From: Farhad Aarabi [REDACTED]
Sent: 25 February 2014 16:50
To: Janice Chapman
Subject: RE: BE/4/14 - Loft conversion with front and rear dormer at 40 Norbren Avenue, Bersted

From: [REDACTED]
To: [REDACTED]
Subject: BE/4/14 - Loft conversion with front and rear dormer at 40 Norbren Avenue, Bersted
Date: Tue, 18 Feb 2014 15:49:34 +0000
Dear Mr Aarabi,

Proposed Front Elevation (North)

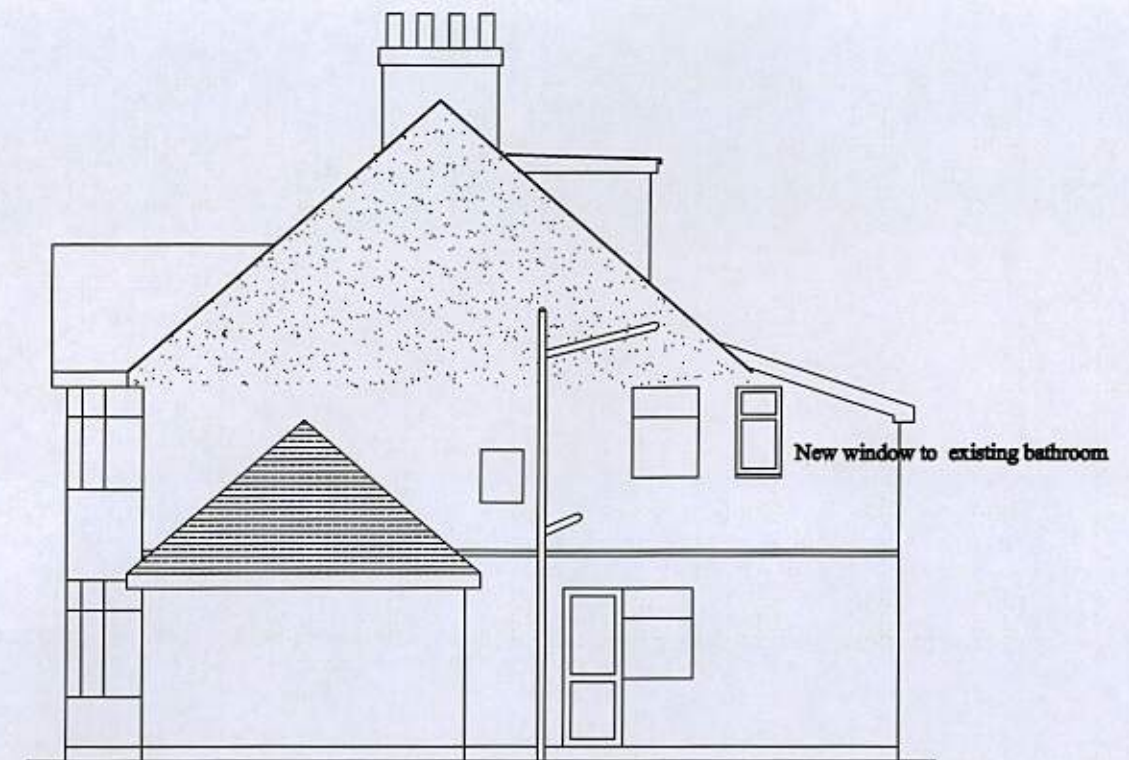
I have visited the site in relation to the above loft conversion. Whilst I have no objection in principle to the loft conversion with alteration to the roof the front dormer is not considered acceptable. There is the absence of front dormers in the surrounding street which are characterised by properties of similar style and design.

Would it be possible for the front dormer to be removed from the application.

Dear Mrs Chapman,
with reference to your e-mail with regard to front dormer, The front dormer can be removed from application and only back dormer to stay as it is. will you please accept this as confirmation that the front dormer to be disregarded, so permission can be granted.
